CITY OF ALBUQUERQUE

June 25, 2025

Re: Circle K
9610 Eagle Ranch NW
30-Day Temporary Certificate of Occupancy
Transportation Development Final Inspection
Engineer's Stamp dated 8-14-23 (C21D028)
Certification dated 6-26-2025
TRANS-2025-00169

### SITE PLAN

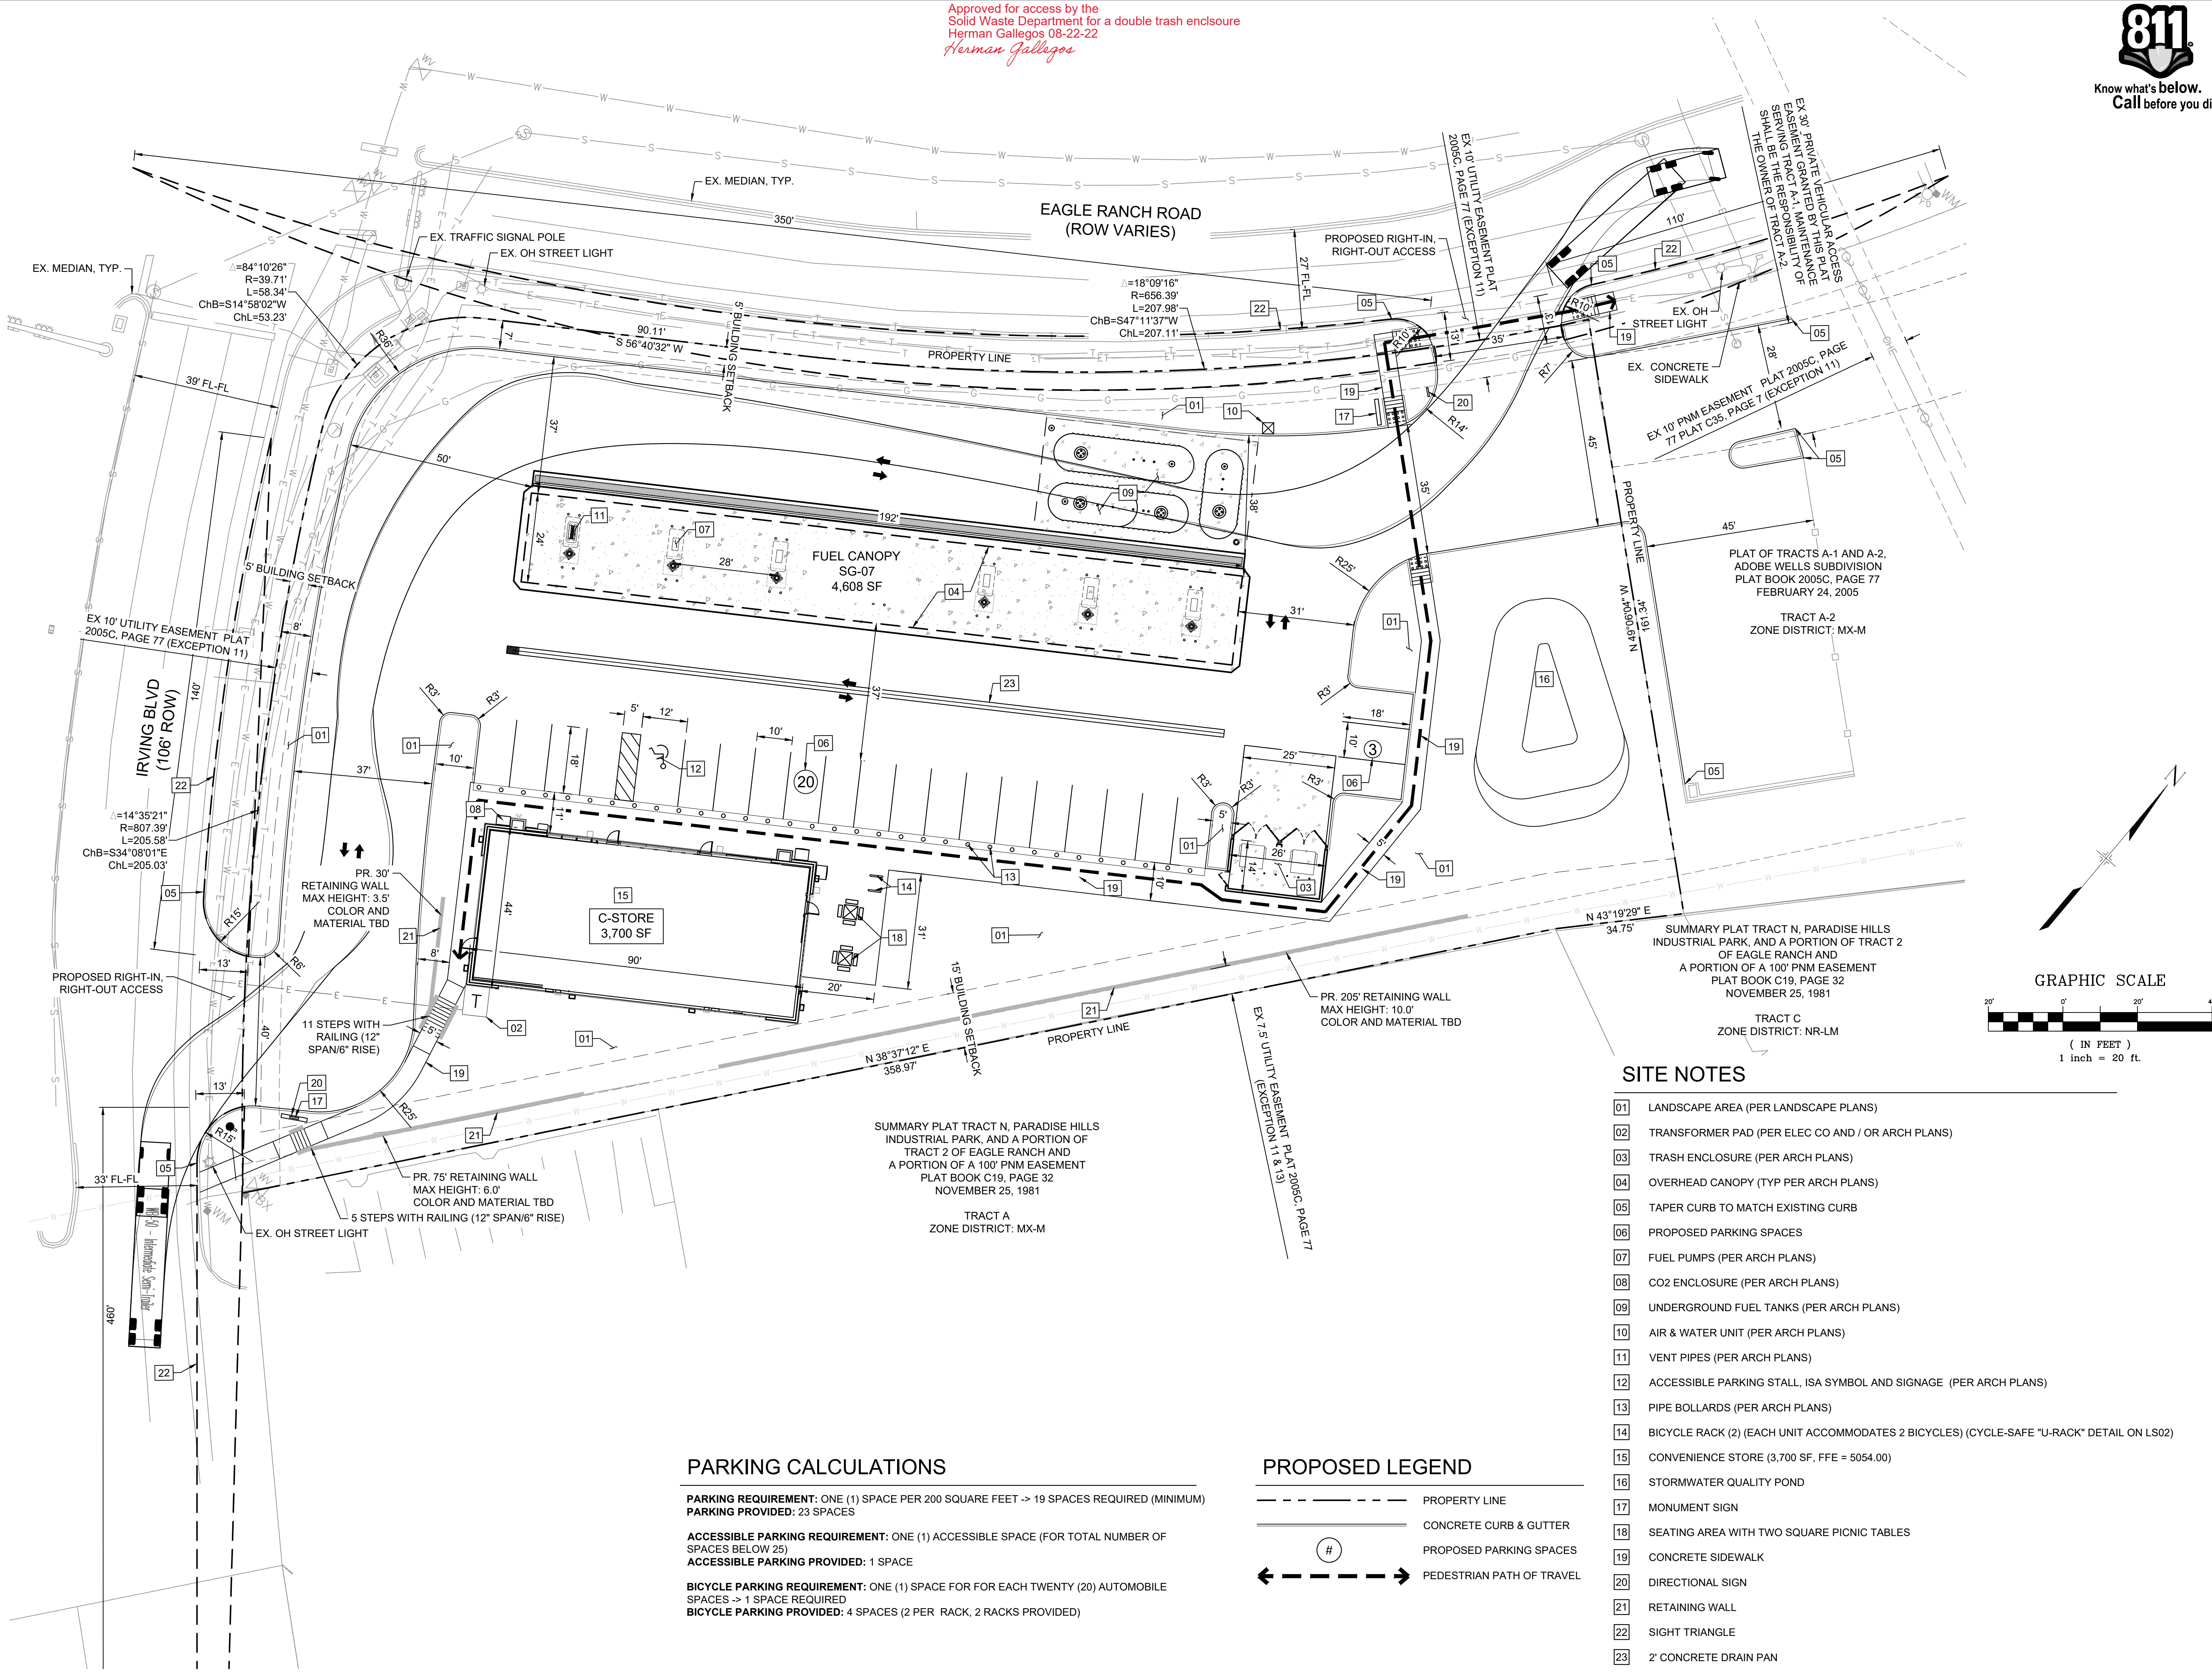
1. Relocate the Dumpster

2. Install bike racks, they are missing

3-Van access aisle should be 8 ft wide with blue color striping and lettering as shown below
